PORTLAND MAINE

March 16, 2009

RE: 8 Ryefield Street, Peaks Island – 084 E005 – IR-2 – enclose porch – permit #08-1580

Drawing file: 1. Original Plans / Existing Plan.pdf

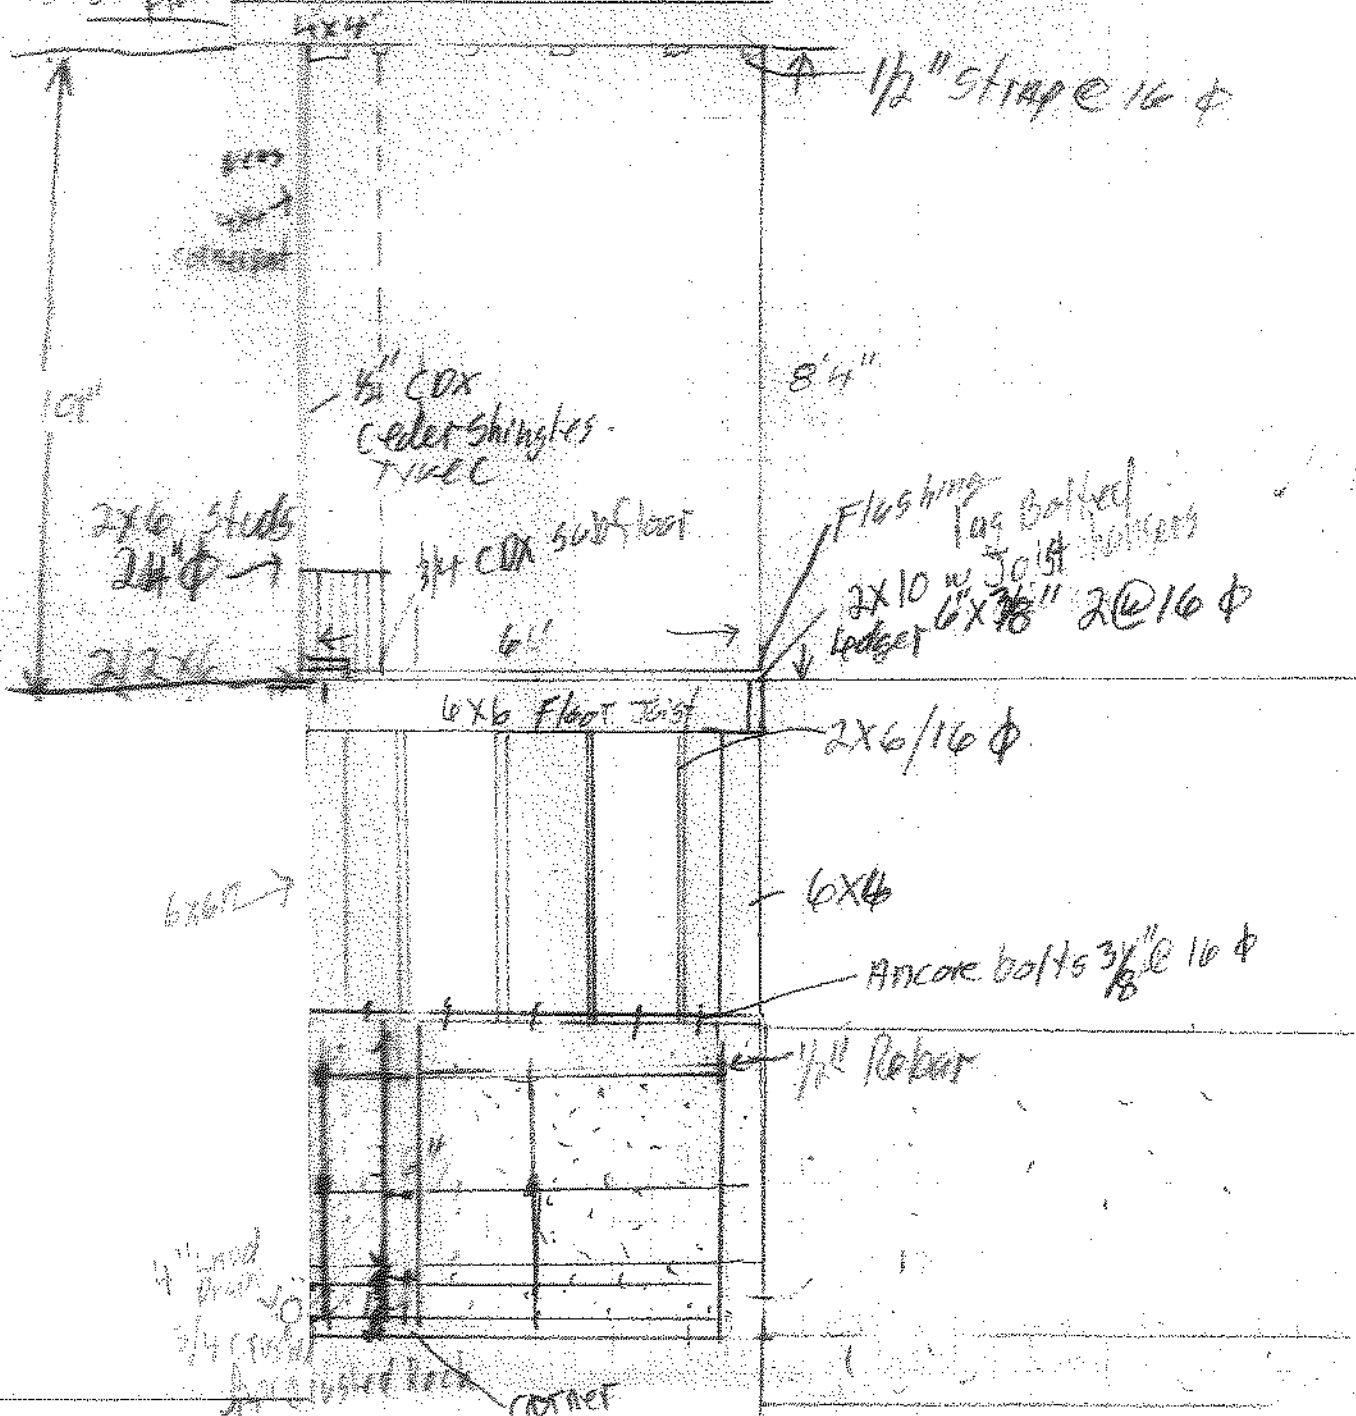
As you know, I have been working with your contractor Terry Edwards on your application to enclose the six foot by twenty-eight foot porch on the side of your house at 8 Ryefield Street, Peaks Island. At this point, I must deny your application.

The existing open porch sits right on the side property line and does not meet the minimum required side setback of twenty feet [section 14-145.11(c)(3)]. Section 14-427 allows the enclosure of an open porch that encroaches into a required setback if it existed on June 5, 1957, but the major portion of the enclosure has to be glass. The most recent plan of the enclosed porch submitted on February 25, 2009 does not meet the criteria. The proposed windows and door cover 18.3% of the total wall area which is under the required 51%.
